PROJECT 8140 CESSNA DRIVE LOT 7, BLOCK 1, MEADOW LAKE AIRPORT FIL. NO. 2 EL PASO COUNTY

ER DRAINAGE PLANS

DRAWN BY: O.E. WATTS DATE: 11-8-21 DWG. NO.: 20-5498-08	APPROVED BY: PROJ. NO.: DWG.	REVISIONS	OLIVER E. WATTS CONSULTING ENGINEER COLORADO SPRINGS	PROJECT 8140 CESSNA DRIVE LOT 7, BLOCK 1, MEADOW LAKE AIRPORT FILING NO. 2 EL PASO COUNTY	SHT. NO. 2 OF 5 EDB OUTLET DETAILS	SHT. NO. 2 OF 5
---	------------------------------------	-----------	--	---	---	--------------------

ISSUE
DATE:
SHEET:
DP-3
3 OF 10

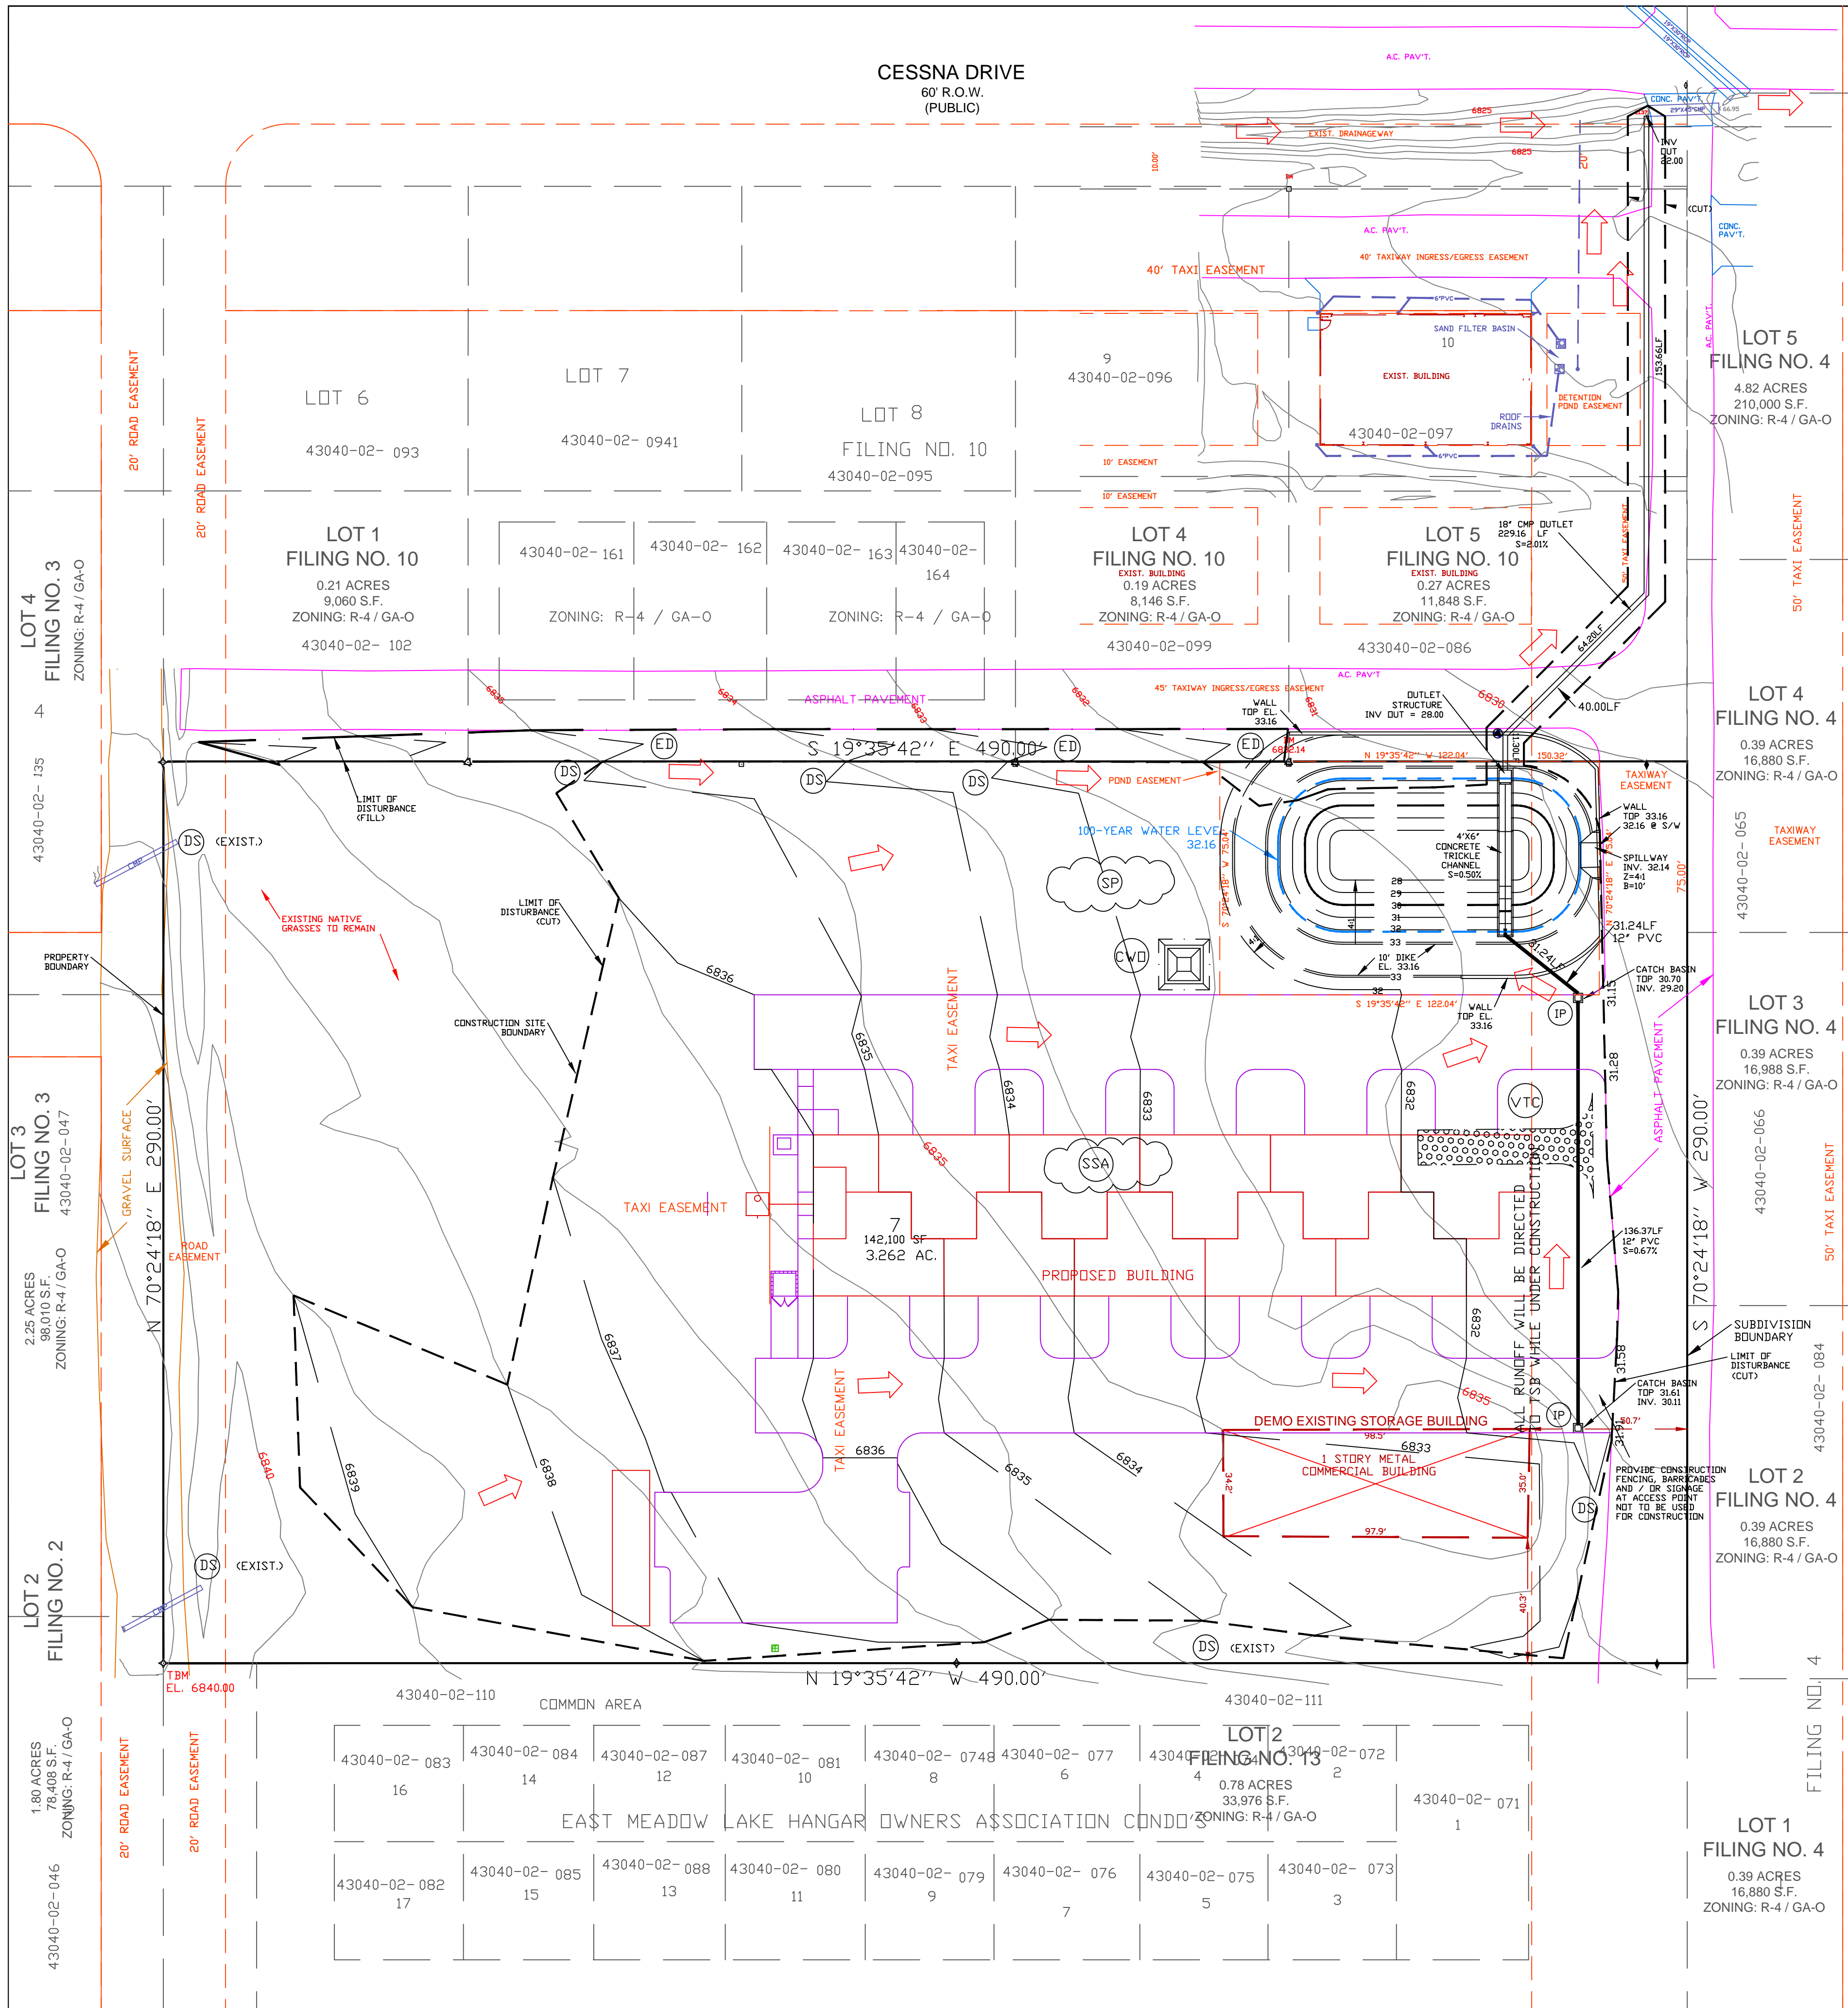
Item x. Will this pond be used as a temporary sediment basin prior to installation of any structures? Please provide details of the TSB, including riser pipe perforation sizing, number of rows, required volume, location of outlet and spillway, and tributary area to the sediment basin.

How will SW be directed to TSB prior to installation of sewer pipe? Provide temporary ditch to TSB to keep SW from running offsite. (SWMP Checklist Item 17g)

Item V. Label all proposed temporary construction BMPs by phase of implementation (initial, interim, final).
Show temporary and permanent seeding locations (SWMP Checklist Item 17h)
Include inlet protection at catch basins and outlet structure

add notes about
- existing vegetation (Item 1)
- no springs streams, wetlands, etc are within the project area (SWMP Checklist Item 17i)

Define in legend

Item n. Provide construction fence to protect work areas offsite.

Item e and Item h. show construction site boundaries and property boundaries and include in legend

Item w. Provide construction fencing, barricades, and/or signage at access point not to be used for construction.

label existing storm sewers and sizes. Symbol does not match legend

OUTLET WORKS SECTION

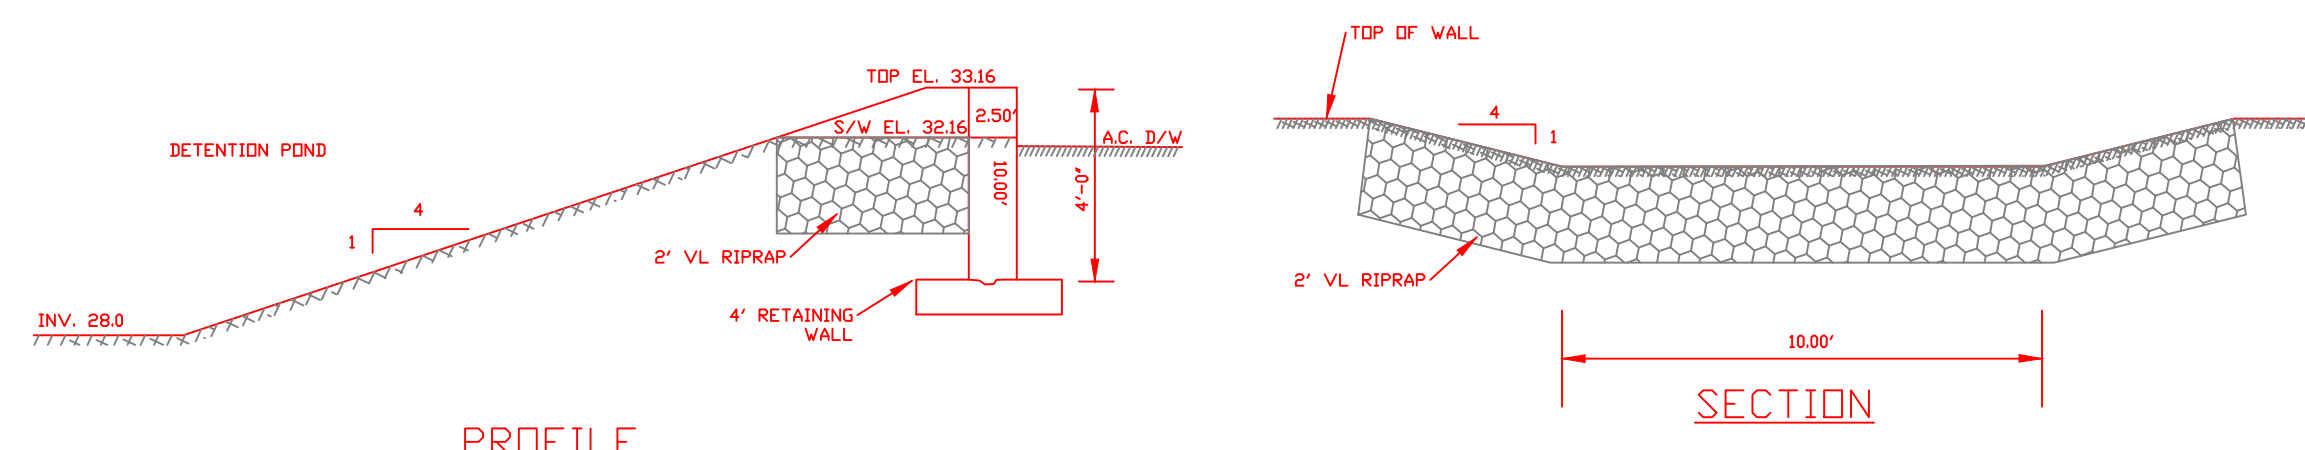
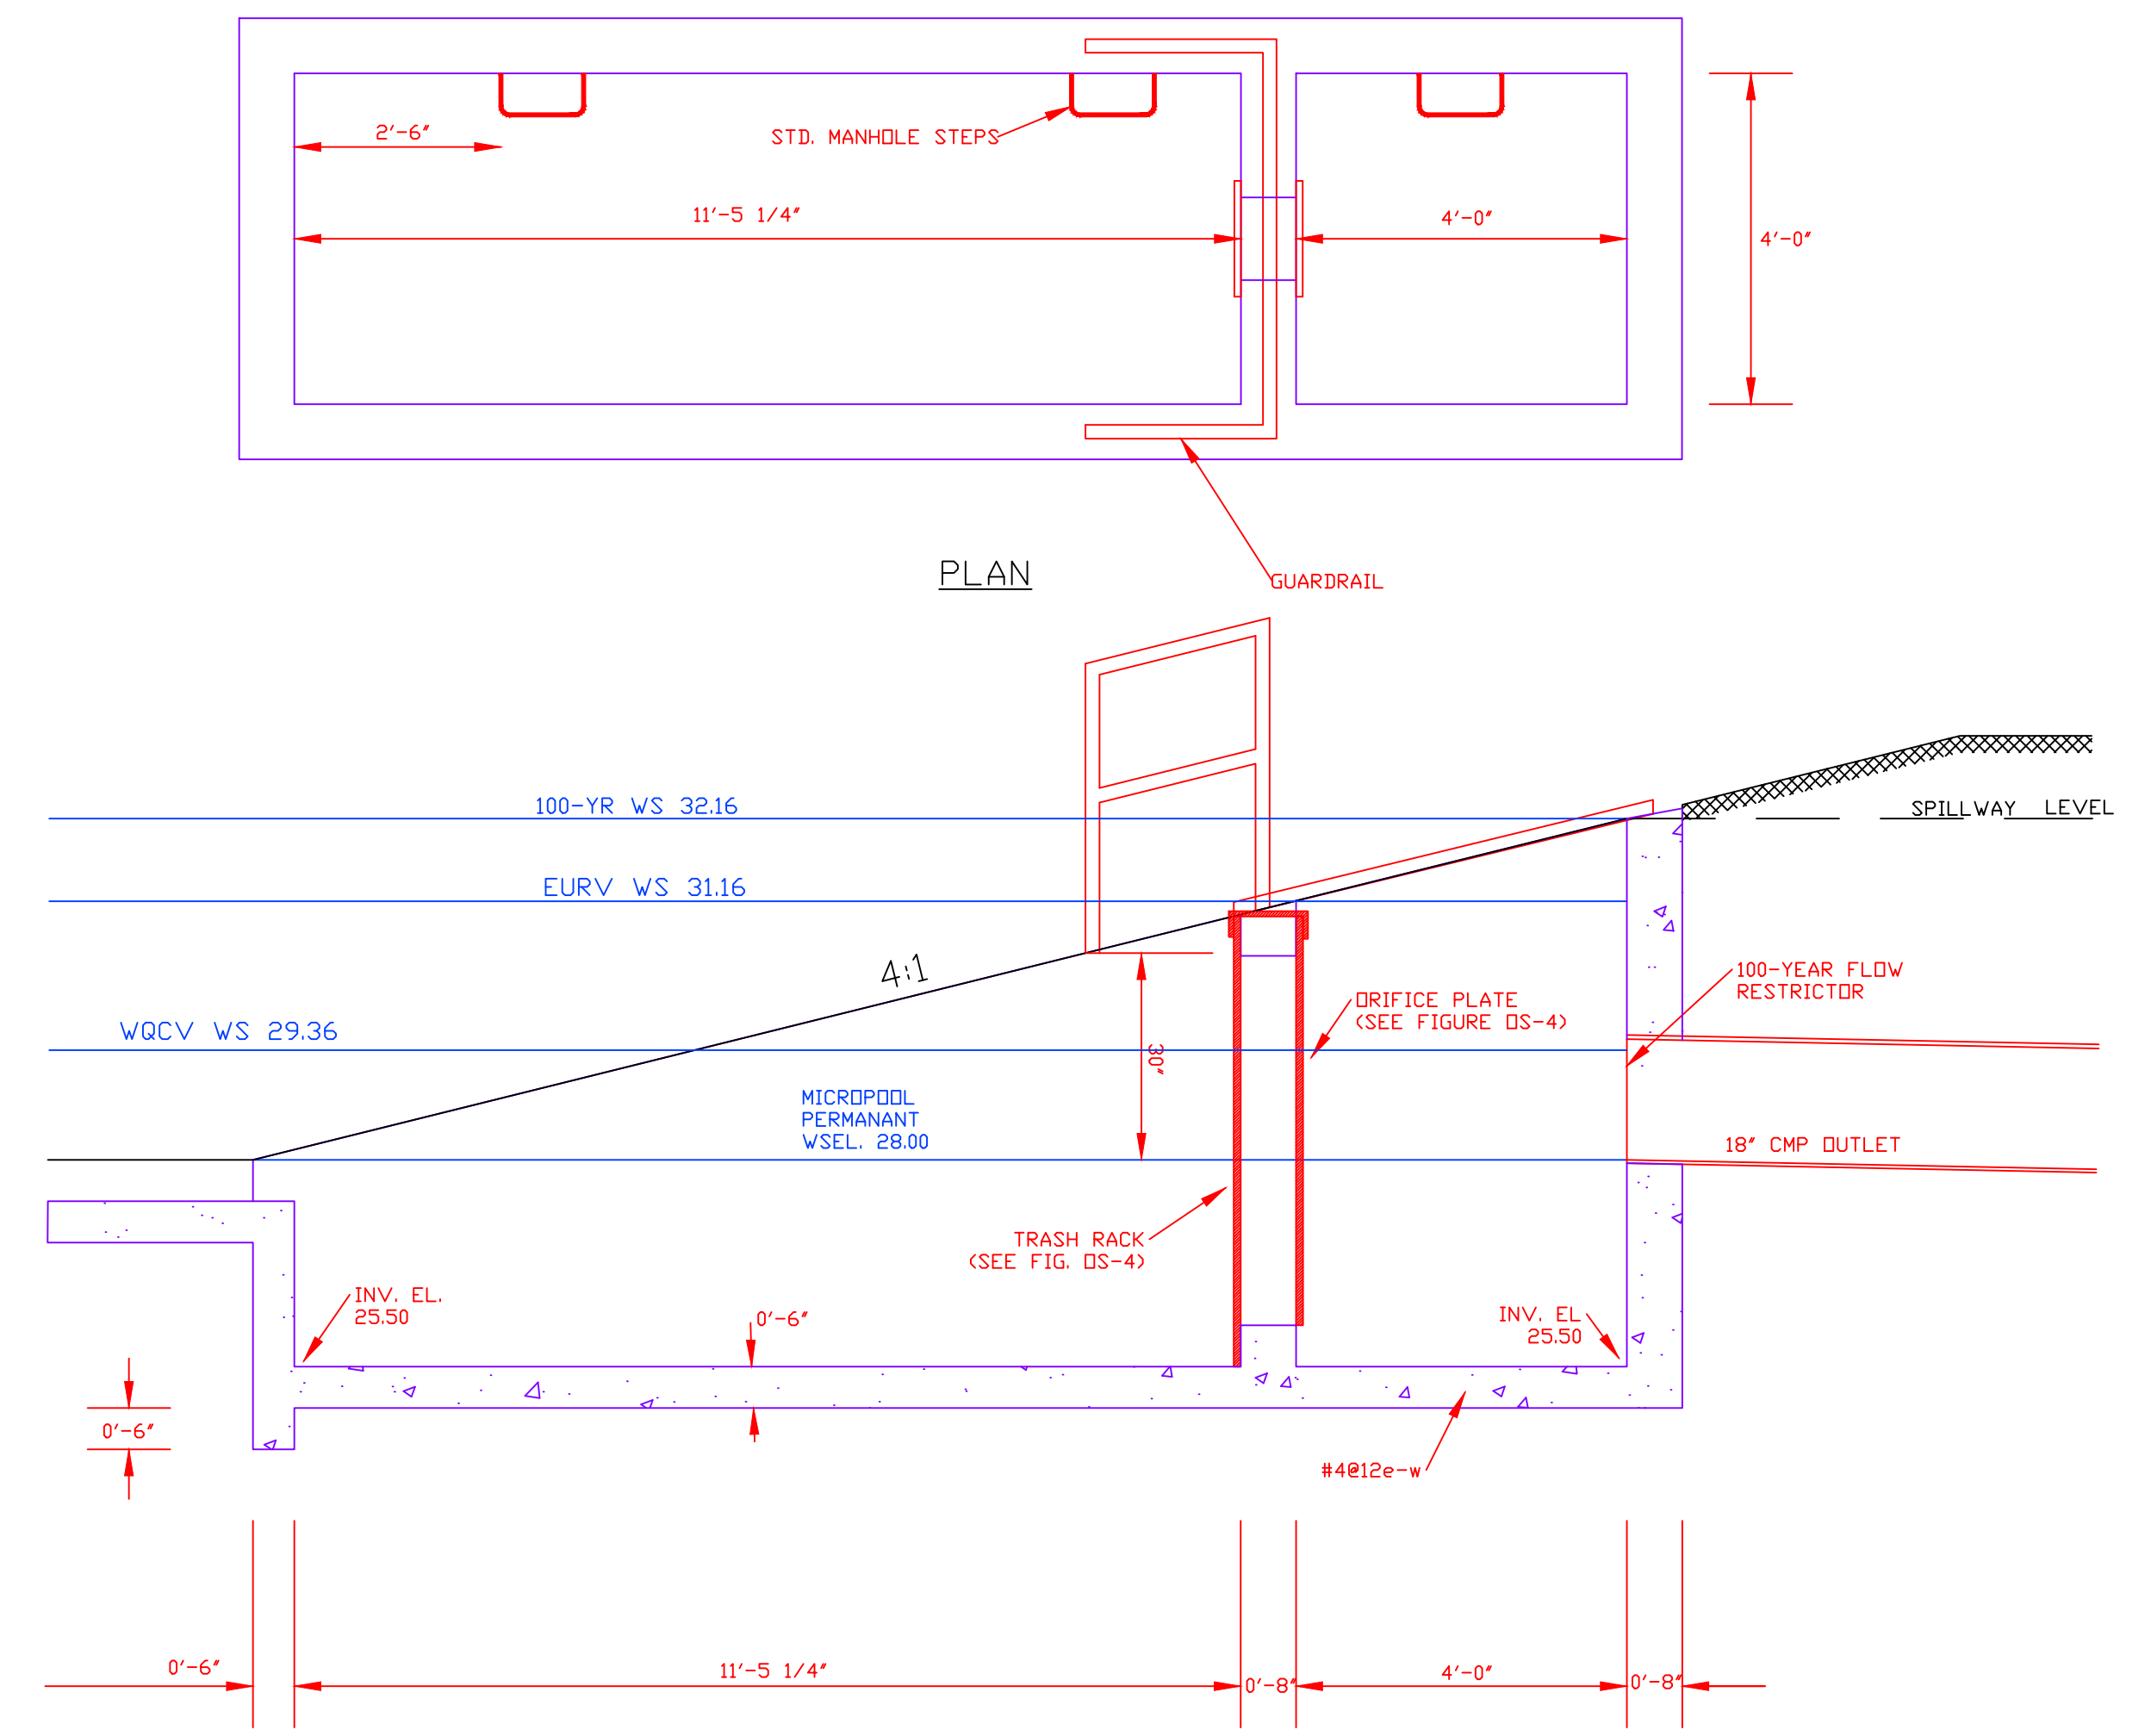
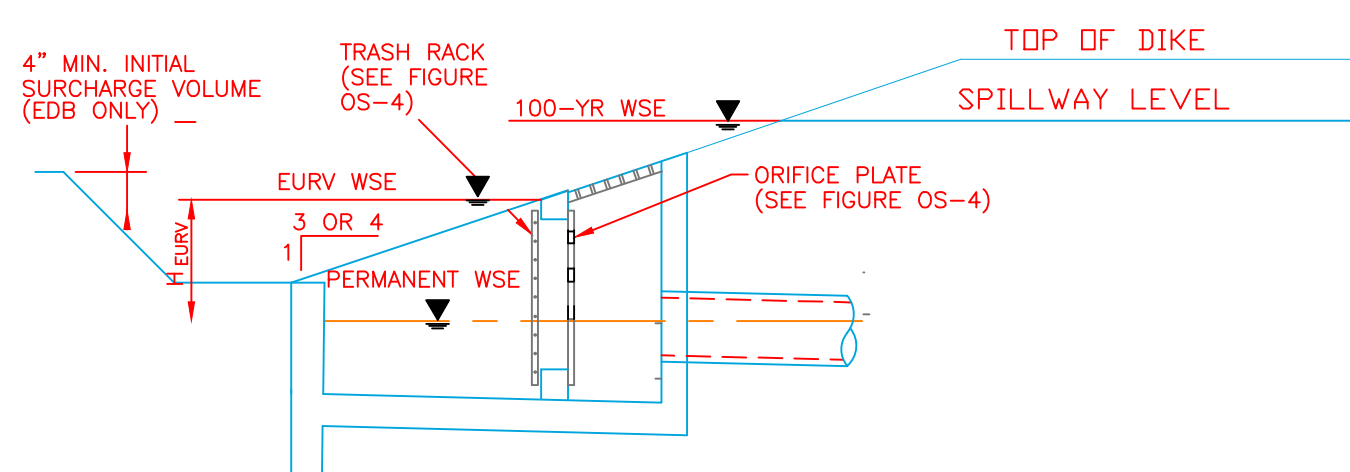
include trickle channel slope to micropool

Per DCM V2 Section 4.3, outlet pipe should be 18" minimum.

what is this clearance?

You have 4 different details for outlet structures, all with conflicting information. Please chose one for design and construction.

provide spillway details
